Sylvia Shriner
181 Sunset Rd.
Ellensburg, WA 98926

Mr. Cory Wright
Kittitas County Board of Commissioners
205 W 5th Ave. Ste. 108
Ellensburg WA 98926-2887

As a resident of the Parke Creek area for thirty years along with my husband and family, it has come to my attention that Brown & Jackson, Inc. has plans of building and operating two septage ponds at the mouth of Parke Creek Canyon. After perusing the SEPA Application, the Addendum, and the Grading Permit, there are some aspects of this plan that I would like to address.

**BROWN & JACKSON**  
 Land Application Site  
 Preliminary  
 Site Map  
 Kittitas County  
 Washington

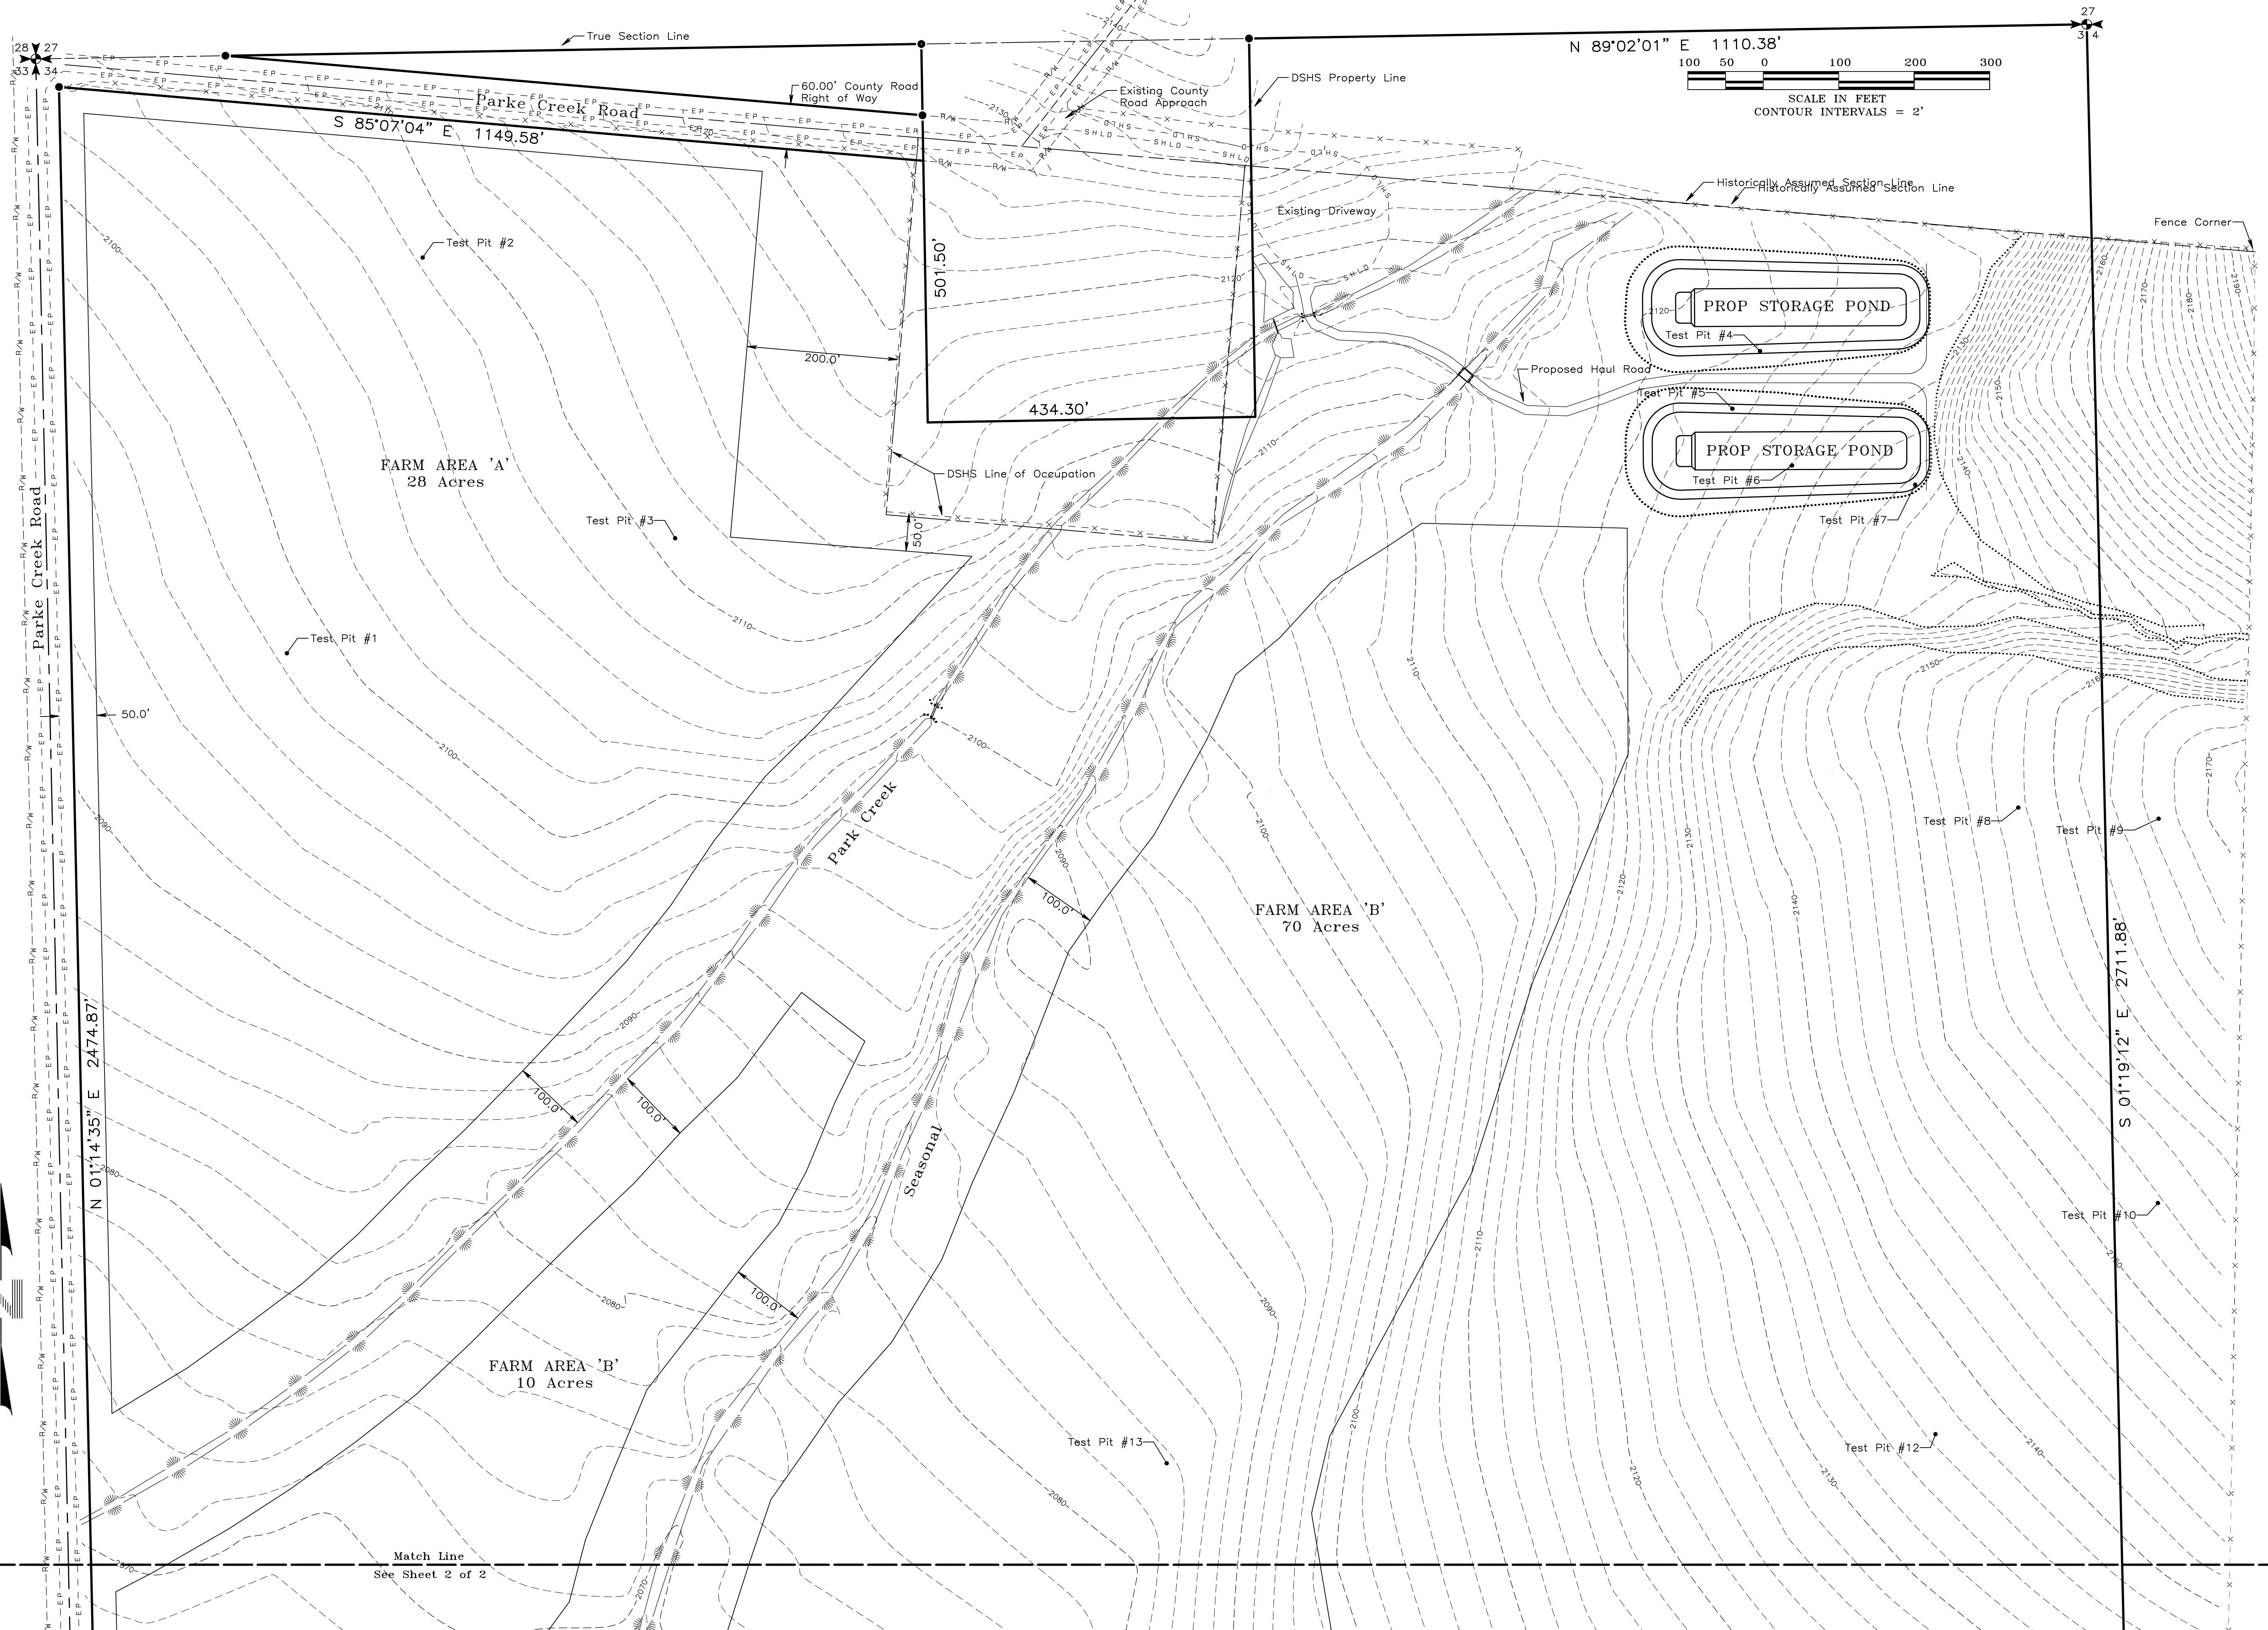
2) The plan states that there should be no expected runoff of waste materials into the ground or surface water. However, if a leak occurs in the lining of one or both of the ponds, the effluent will run down or be absorbed into the creek bed due to their location 10 feet above the lowest point. If the leak goes undetected for a protracted period of time, the effluent will enter the ground water, which could contaminate well water for people in the area who depend on their wells for drinking water. It could also adversely affect people's fields that are irrigated by water from the creek and the ground water that people pump from their wells for irrigation.

In c. 1) The statement that, "This area receives less than 9" of rainfall per year, therefore storm water will infiltrate naturally" does not take into account that Parke Creek has been known to flood in the winter or spring with runoff from the snow in the mountains. This is not an occurrence that happens very often; however, if there is ever an overtopping, a leak or other malfunction of the lagoons, it could be a very serious situation for all who are downstream.
